2018
Site Address: 8 East Bank North End Road Yapton BN18 0DJ
Grid Reference: 498128 104136
Description of Works: Driveway to front of property & new vehicular access.

WEST SUSSEX COUNTY COUNCIL CONSULTATION

TO:	Arun District Council FAO: Mr K Roberts
FROM:	Highways, WSCC
DATE:	03/10/2018
LOCATION:	8, East Bank, North End Road, Yapton, Arundel, BN18 0DJ
SUBJECT:	Y/69/18/HH Driveway to front of property & new vehicular access.
DATE OF SITE VISIT:	N/A
RECOMMENDATION:	☒ Advice ☐ Objection ☐ Modification ☐ No Objection ☐ More Information ☐ Refusal
S106 CONTRIBUTION TOTAL:	£N/A

site plan

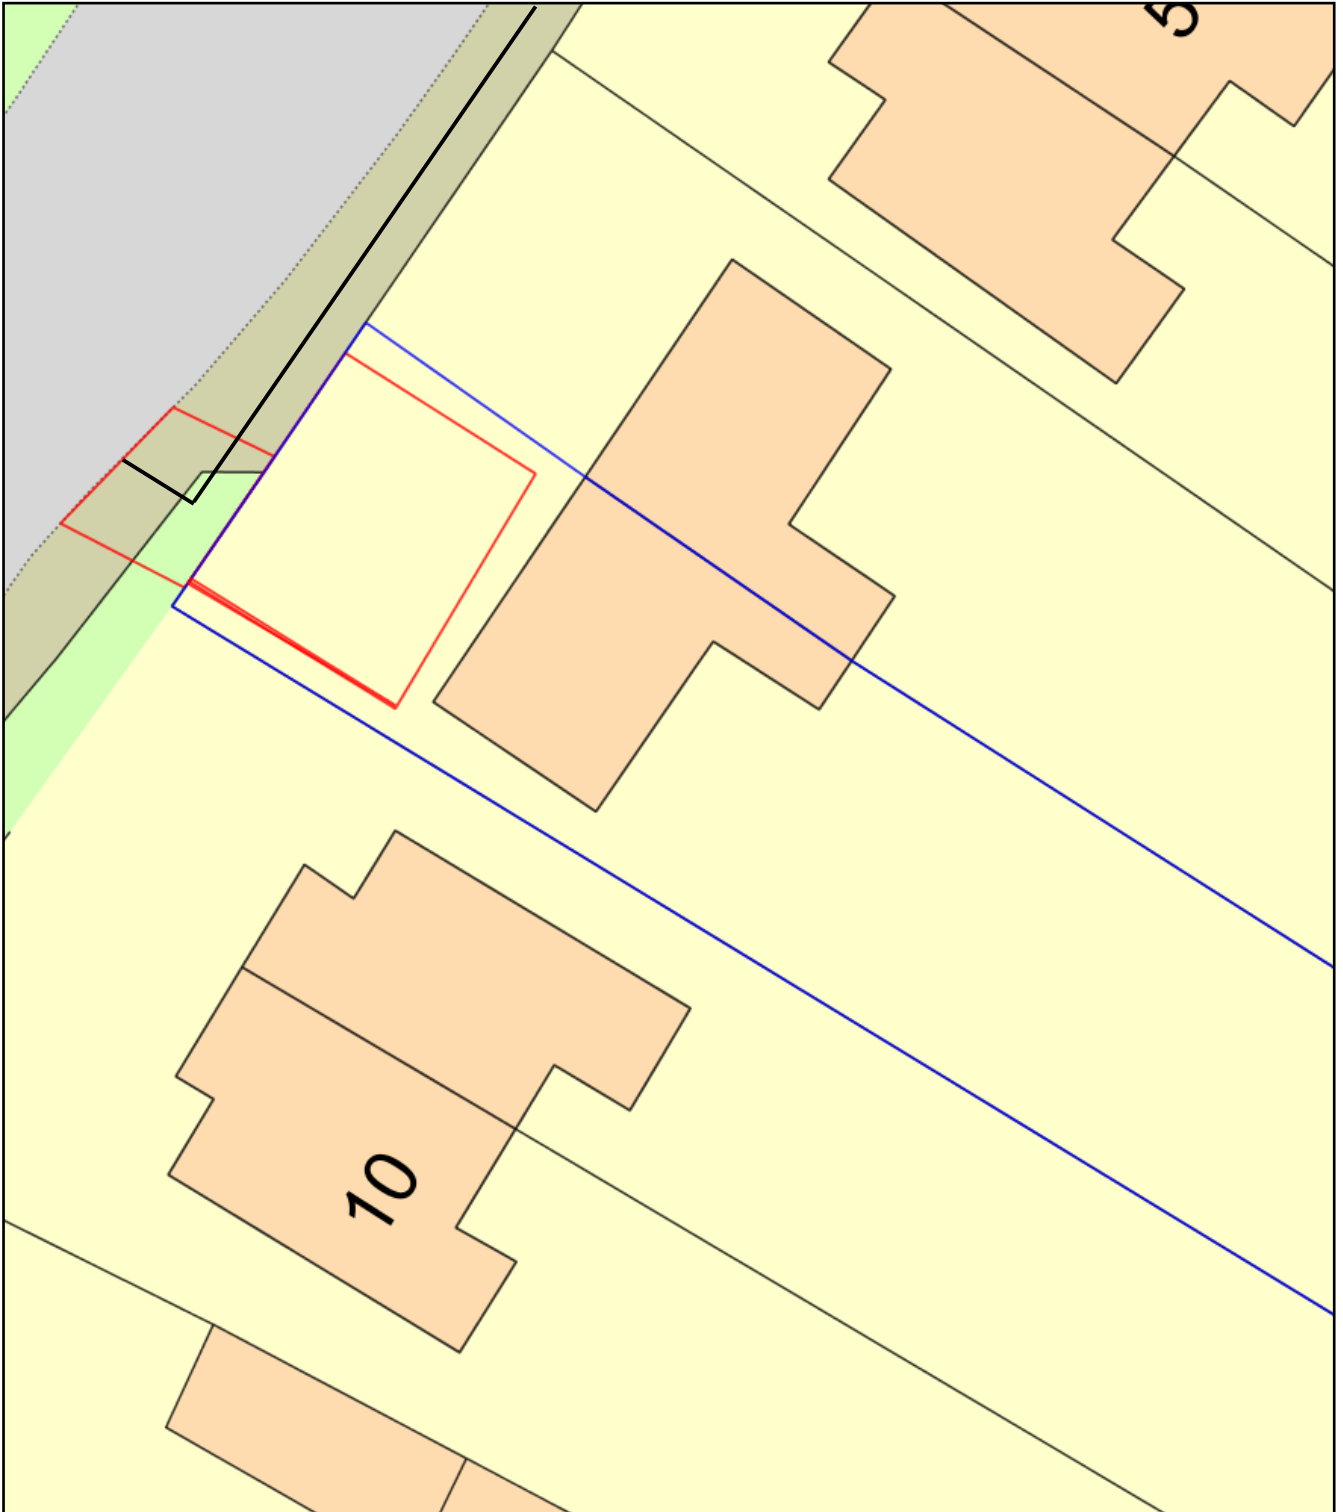
The proposed vehicular crossover (VCO) will be approximately 4.2m wide. A licence will be required for the VCO and should be constructed to a specification agreed with the Local Highways Engineer. The applicant should be aware that this area is subject to a policy that a licence may not be granted for a through-layby crossover to any property, due to the existing parking pressures and the loss of on-street parking provision for neighbouring residents. It is recommended that the LPA consider the amenity impact of the proposed development should permission be granted.

The applicant has not provided vehicular visibility splays for the proposed access; however, WSCC mapping indicates that visibility is sufficient for the anticipated road speeds. An inspection of data supplied to WSCC by Sussex Police over a period of the past five years reveals that there have been no recorded injury accidents within the vicinity of the site and therefore there is no evidence to suggest that the addition of a VCO in this location would exacerbate an existing safety concern.

The proposed new driveway appears to provide sufficient perpendicular parking for three vehicles. The construction of the driveway has not yet been determined by the applicant. Ideally a hardbound surface would be provided. If the driveway is to be constructed from gravel, this may result in material being dispersed onto the public highway affecting the surface of the road. The applicant should provide a gravel trap or area of block paving, or other bound material, at the point of access onto North End Road (on land within the applicant's control; not within the publicly maintained highway). A turn on site would be preferred, clearly though there is insufficient space to achieve this. However other properties have similar arrangements and balanced against this is the benefit of

providing an opportunity to remove up to three vehicles that would otherwise be parked on the highway in a location where the existing practice is on-street parking by residents of adjoining properties which results in a noticeable narrowing of the existing available carriageway space.

No development shall be first occupied until the vehicular access serving the development has been constructed (including a bound material from the back edge of the Highway boundary to prevent gravel overspill) in accordance with plans and details to be submitted to and approved in writing by the Local Planning Authority.

No part of the development shall be first occupied until the car parking has been constructed in accordance with the approved site plan. These spaces shall thereafter be retained at all times for their designated purpose.
